From: Simon Davis
Sent: 04 March 2019 10:49
To: 'Stephen Brooker'
Cc: Rob Murgatroyd
Subject: RE: BR/326/18/PL - The Royal Hotel, The Esplanade, Bognor Regis

Simon J Davis MRTPI | Principal Planning Officer, Planning Department, Directorate of Place, Arun District Council |
Location: Planning, First Floor, Arun Civic Centre, Maltravers Road, Littlehampton, BN17 5LF
Internal: 37874 | External: +44 (0) 1903 737874 | E-mail: simon.davis@arun.gov.uk
Please note that I typically work from home on Thursdays when I am unreachable on my work phone

CLIENT	Metamorph Management LLP
PROJECT	The Royal Hotel Apartments
DATE	December 2018
DRAWING TITLE	Proposed Roof Plan

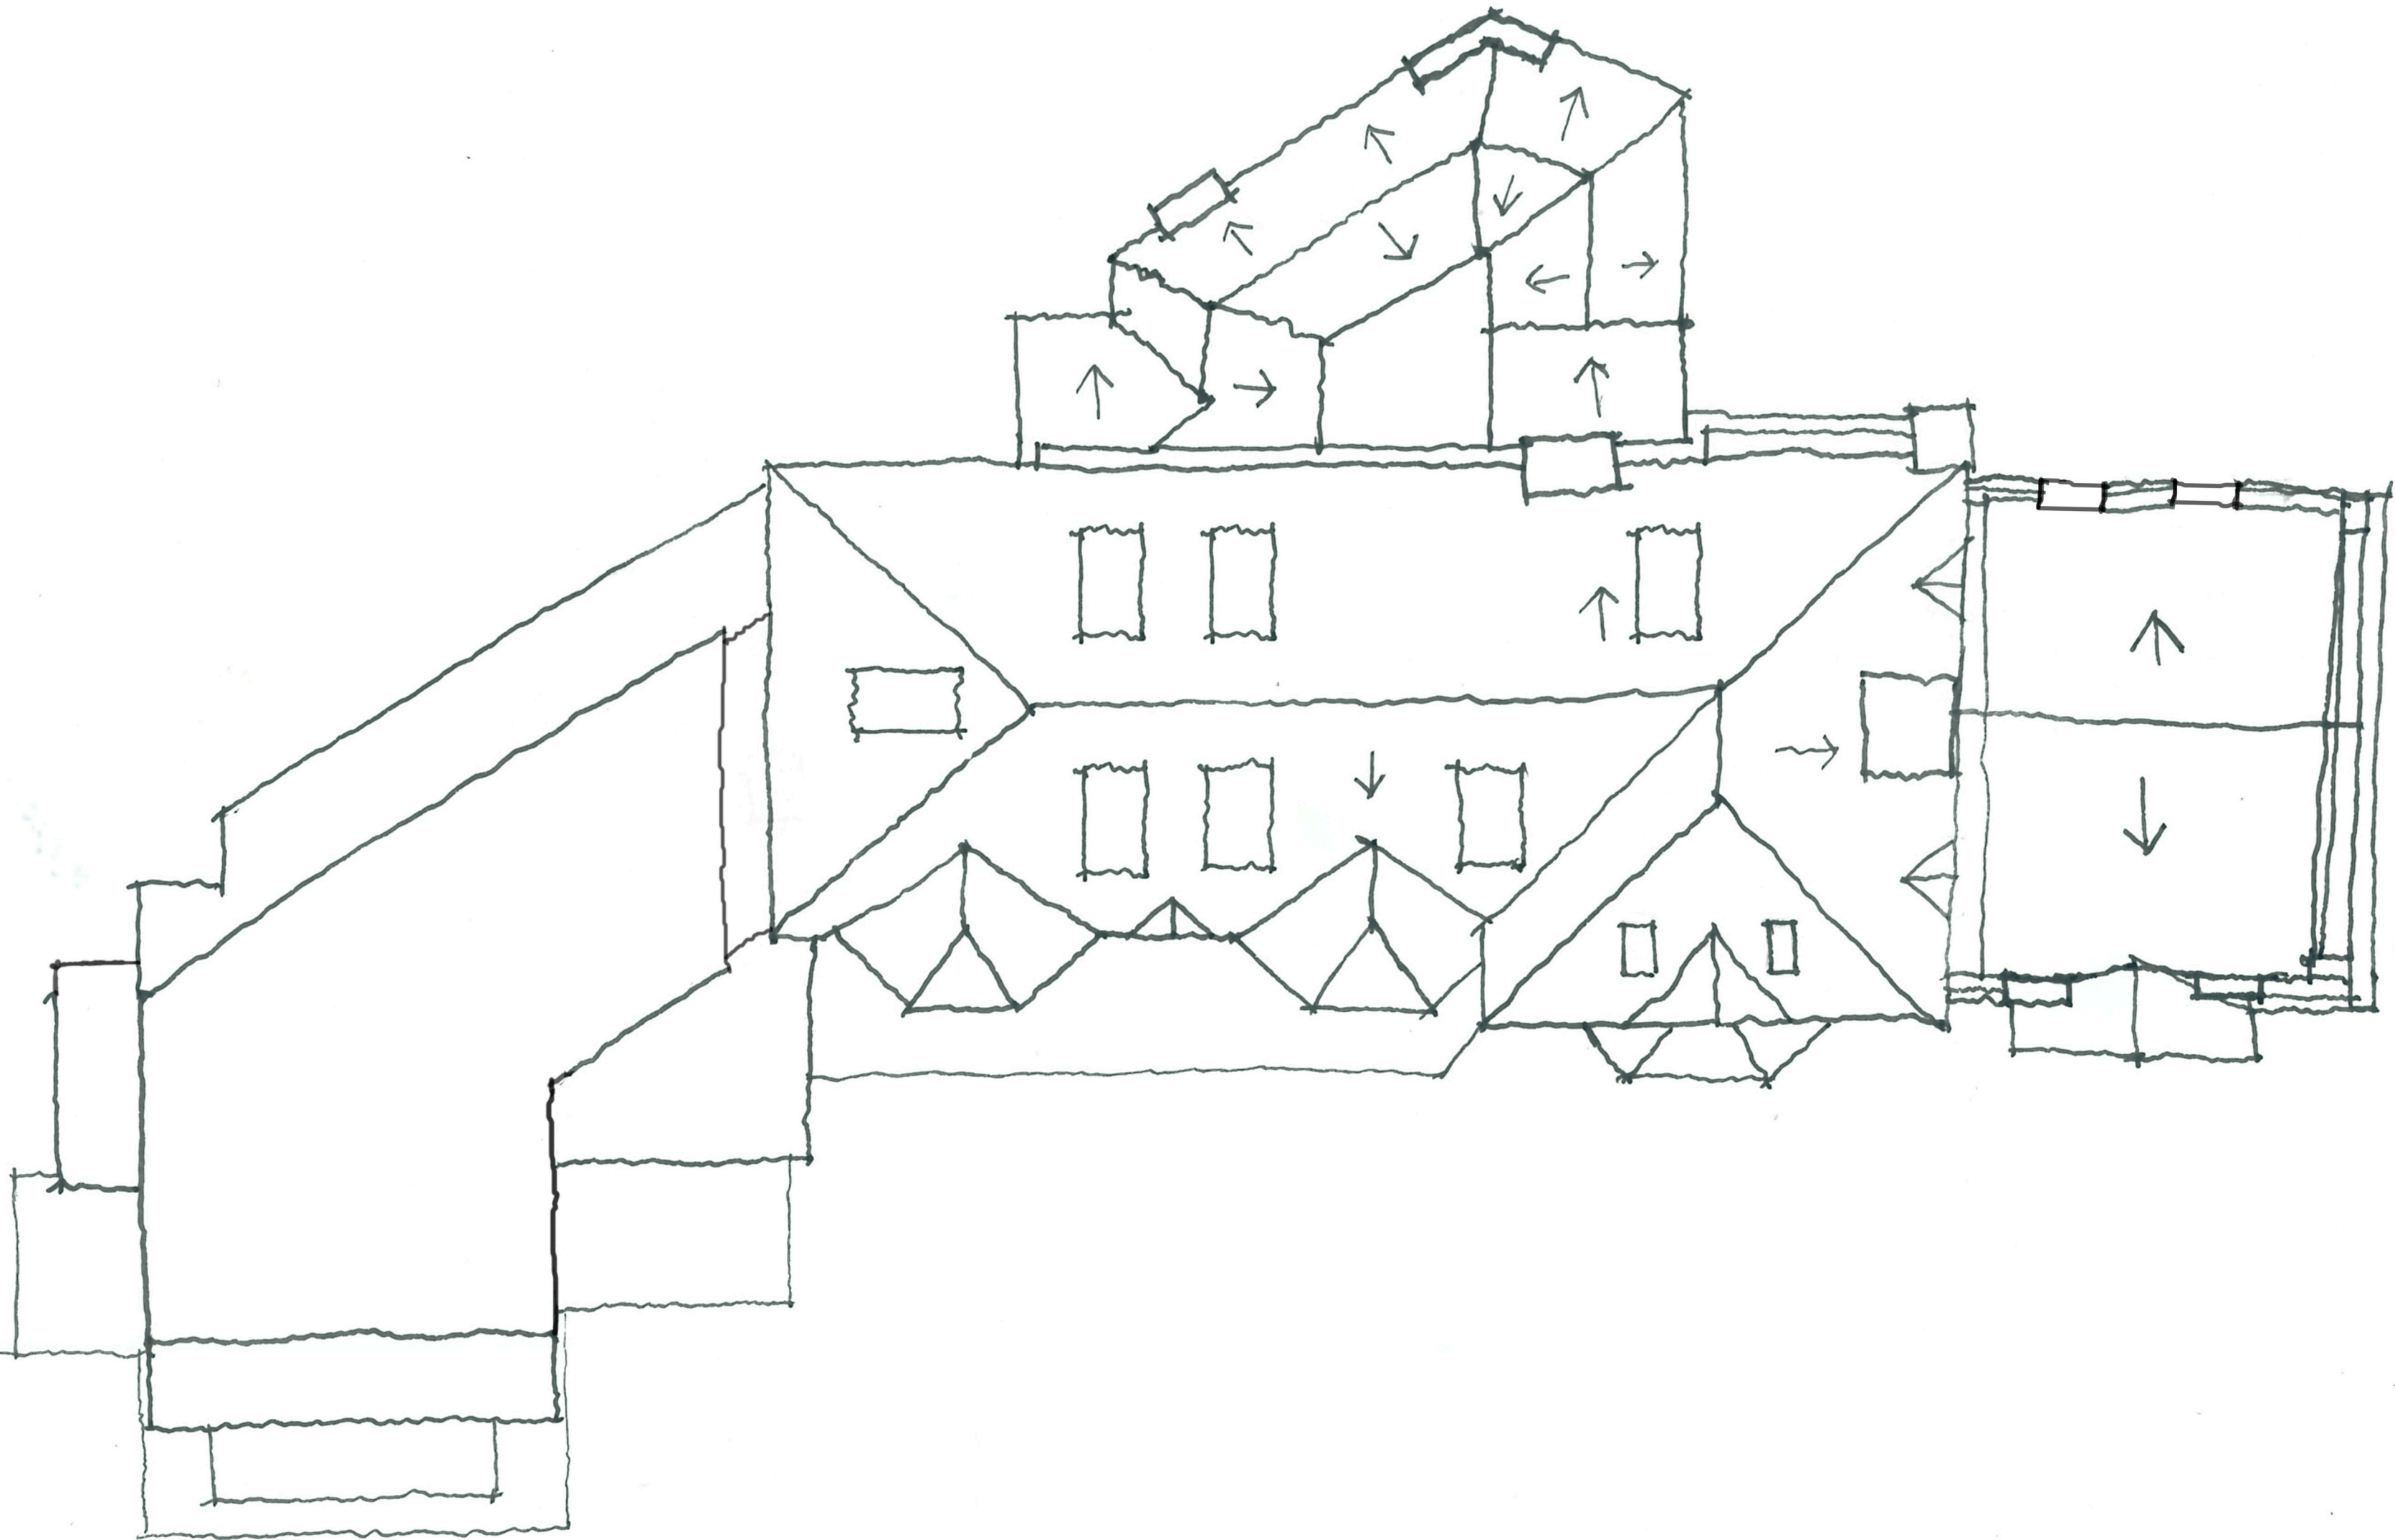
Separately, please see two annotated plans attached. On the roof plan (block plan), it looks like there is a dormer on the eastern flank of the main roof and this is not shown on the N or S elevations. It may be that the missing dormer is actually a velux or the position of the chimney though (as I don't have the fourth floor plan, I haven't been able to check). Also there is a conservation rooflight shown on the N elevation of the main roof but not shown on the roof plan.

One thing he mentioned (and was going to be in his response) was a discrepancy with the plans regarding the dormers on the flank roof planes of the main roof. I think from memory that there are some elevations and possibly the upper floor plan where one or both of these are not shown. I also think he had said that some of the drawings have not made it onto our website. I can't compare to the file at present as Martyn has it but I can't see a third floor plan or an east elevation on the plans we have uploaded. If these are a thing, can you email to me and I'll fix the public viewer. Please also have a look into the dormer issue.
